Interested Party Reference: 20047795

27th November 2024

**Mona Offshore Wind Farm:
Response to ExQ2: 19 November 2024 on Behalf of Tan-y-Mynydd Trout Fishery**

Figure 1.4: Onshore Substation Zones Short List of Options.

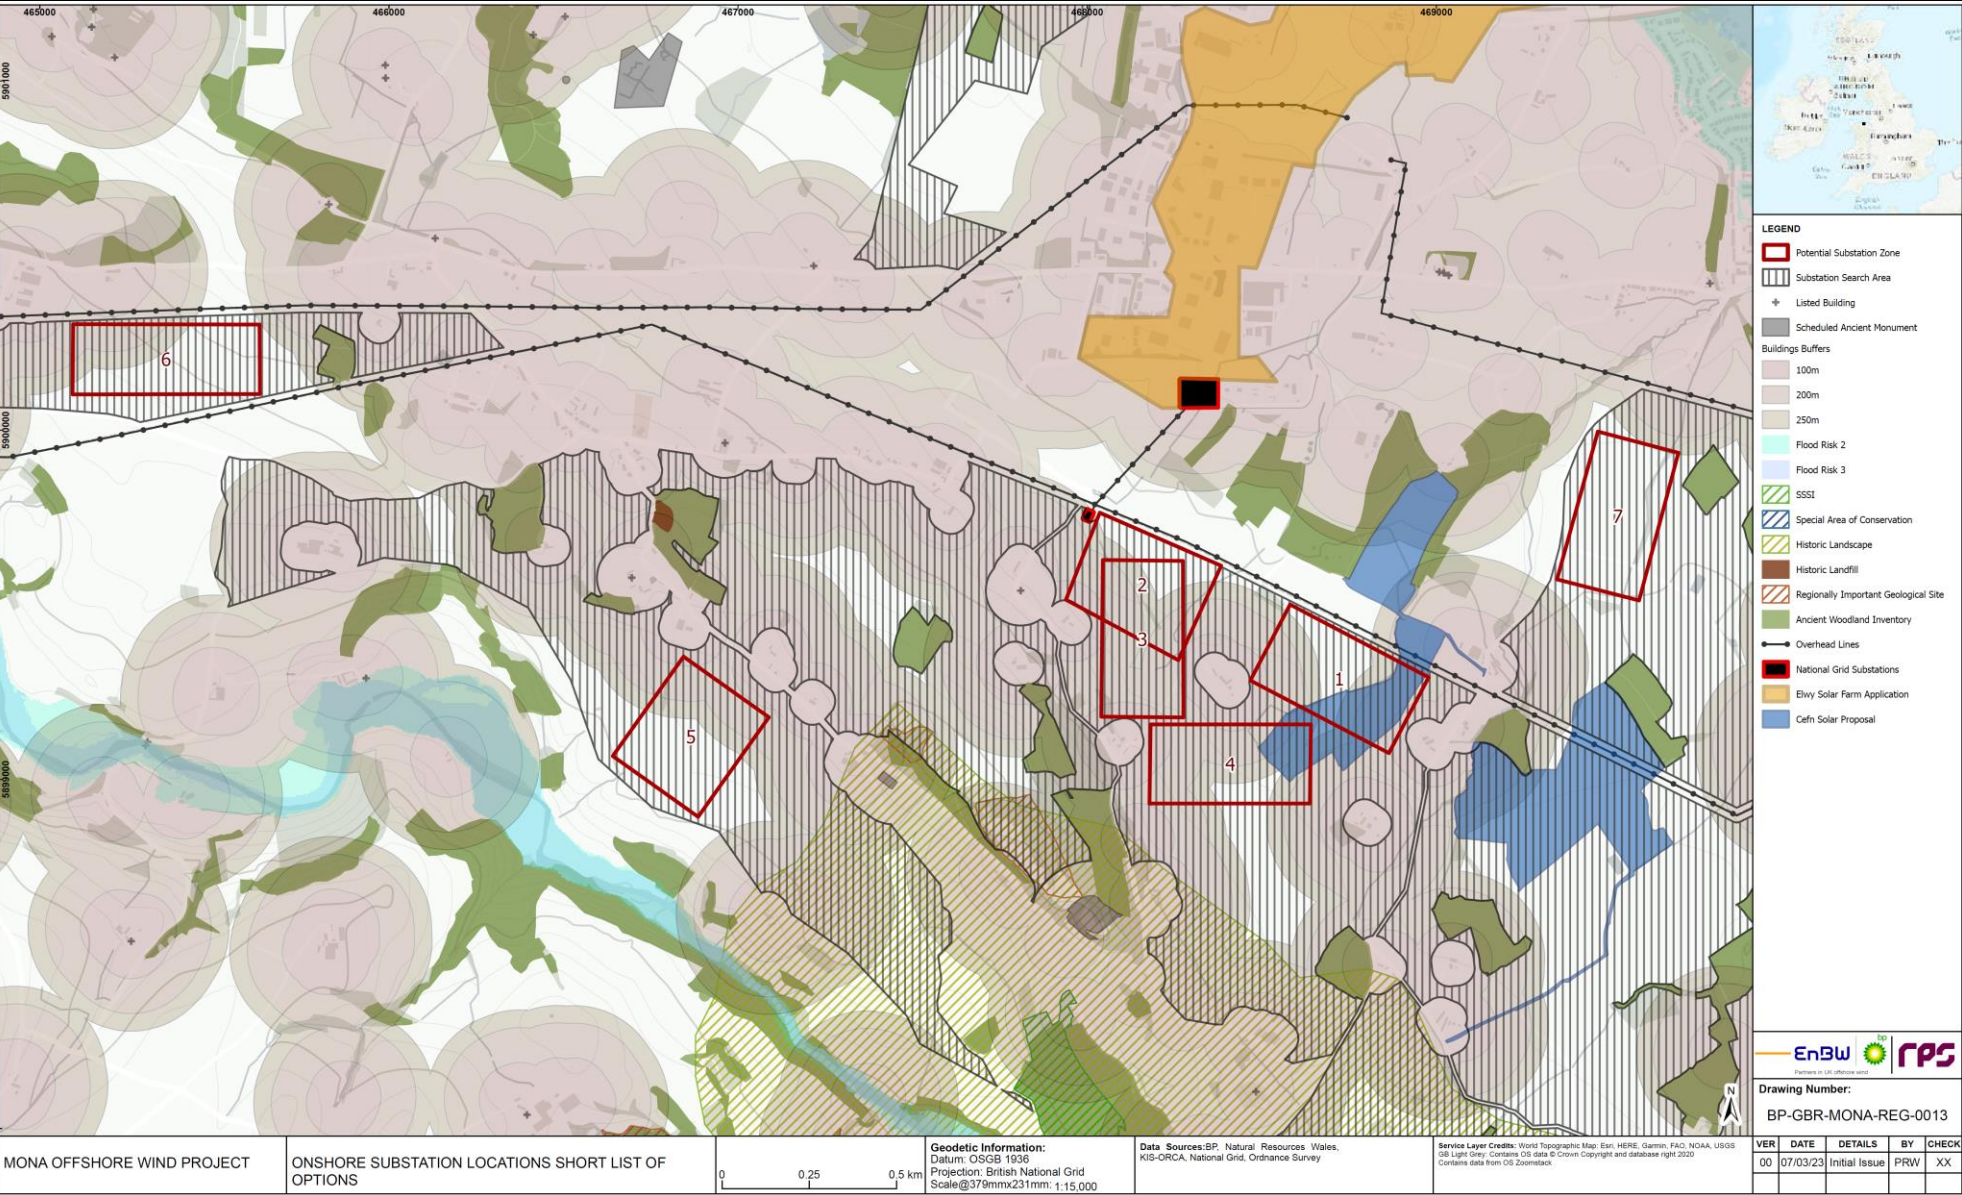
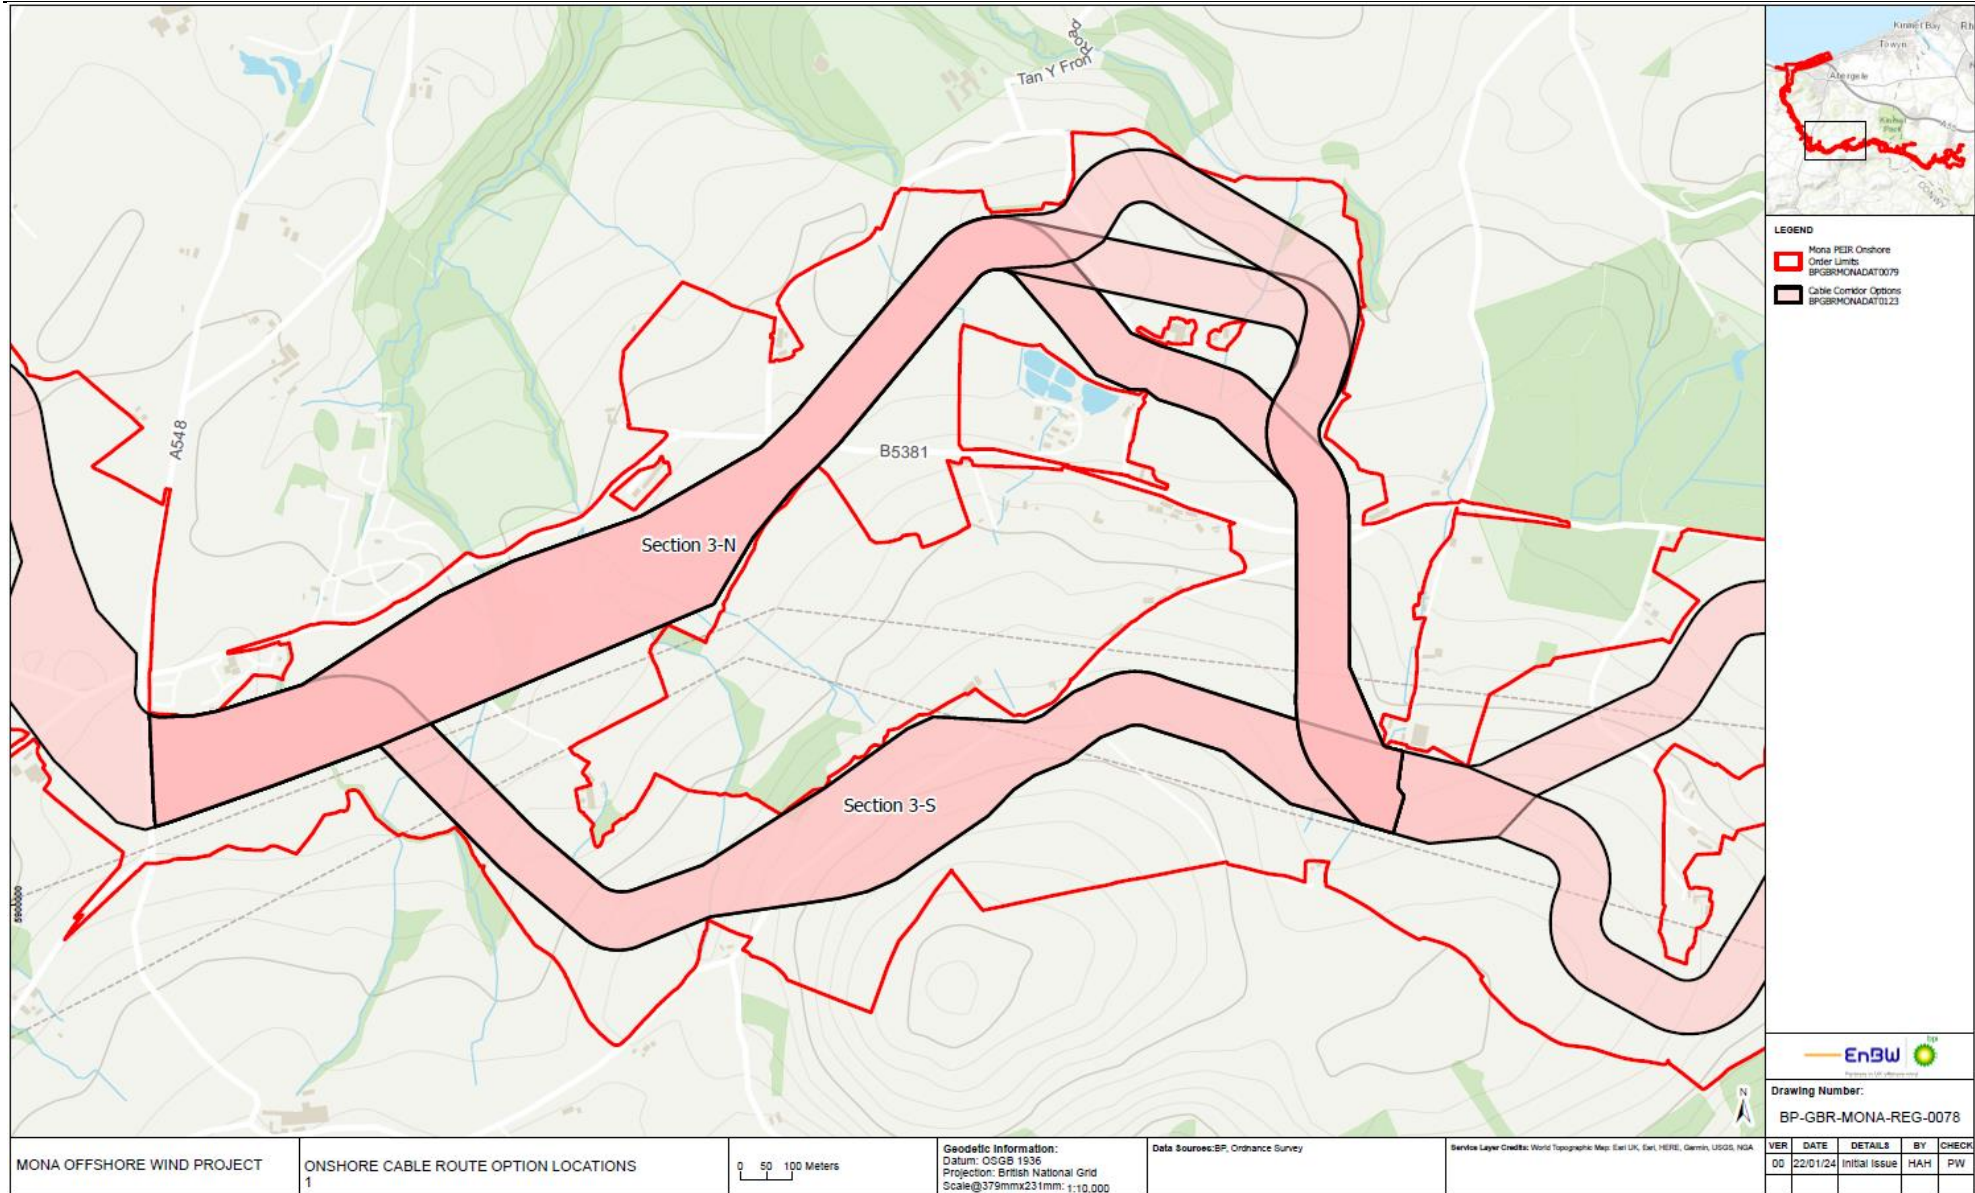
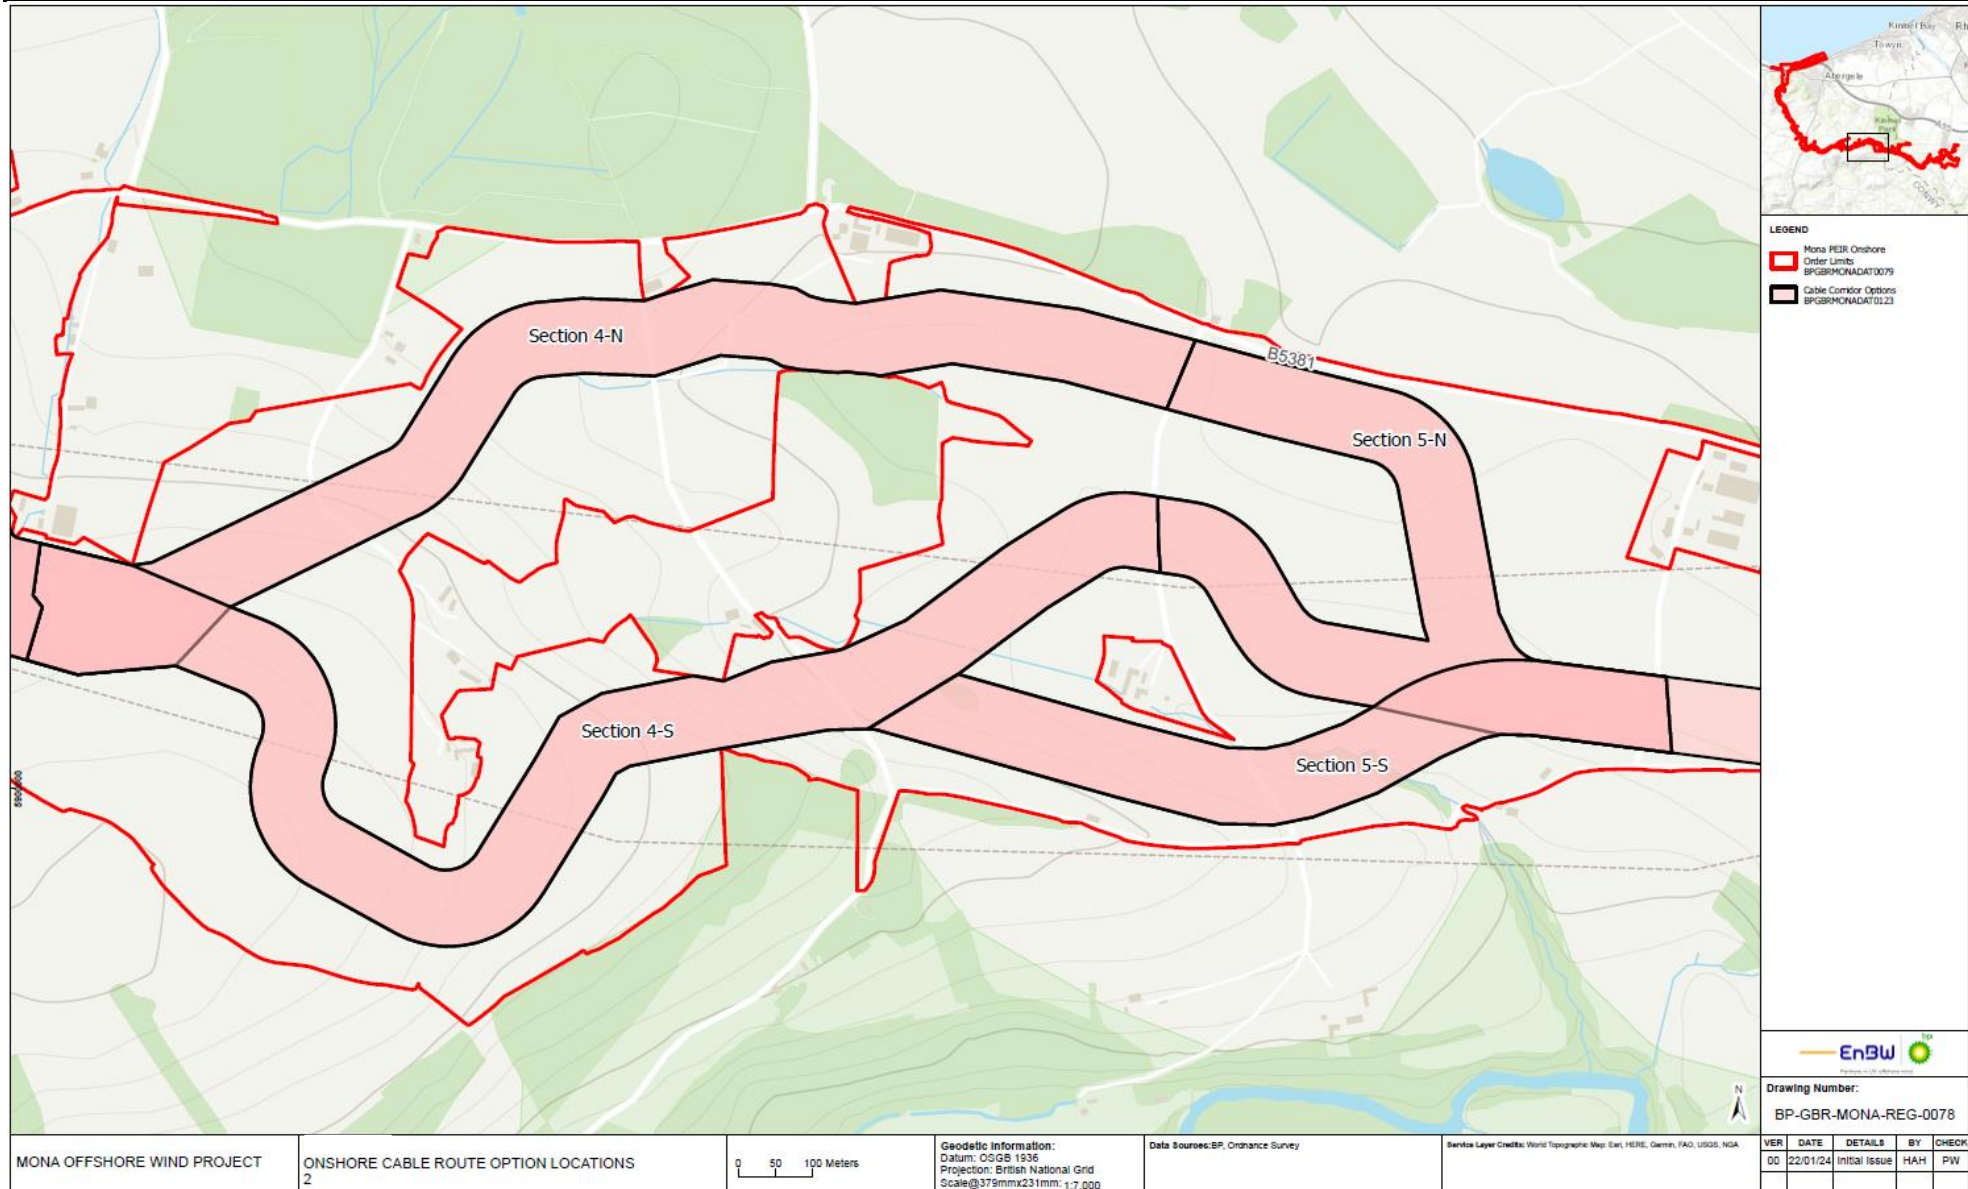
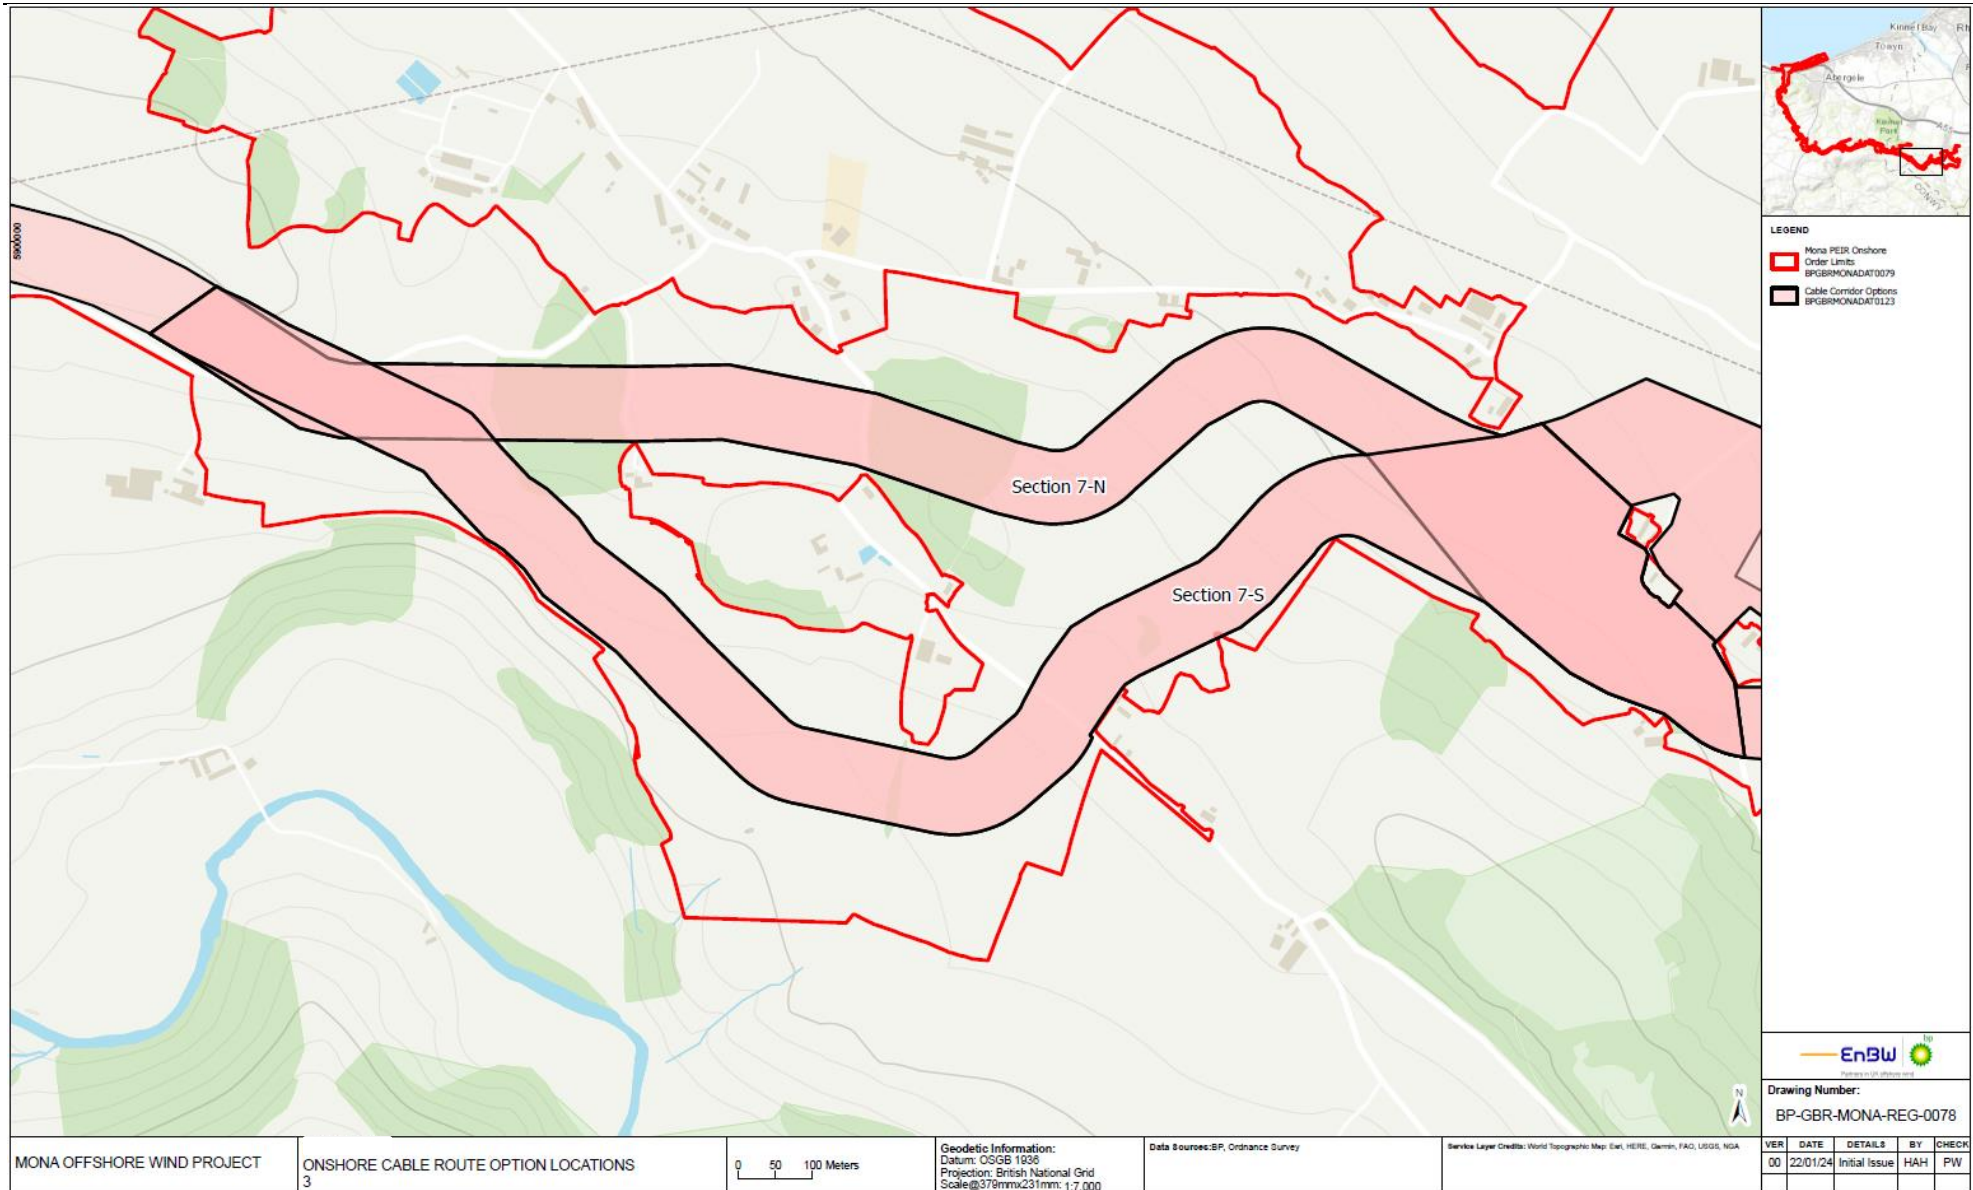
Rep3-107.01: The BRAG report has been received. Sadly, it is very light and 'very subjective', in its consideration of the impacts on the water sources enjoyed by the fishery. This is particularly the case regarding it adopting the Southern cable route. Indeed, based on the overall BRAG report, we would venture that the fishery water sources were at best an extremely minor area of consideration in the grand scheme of route selection.
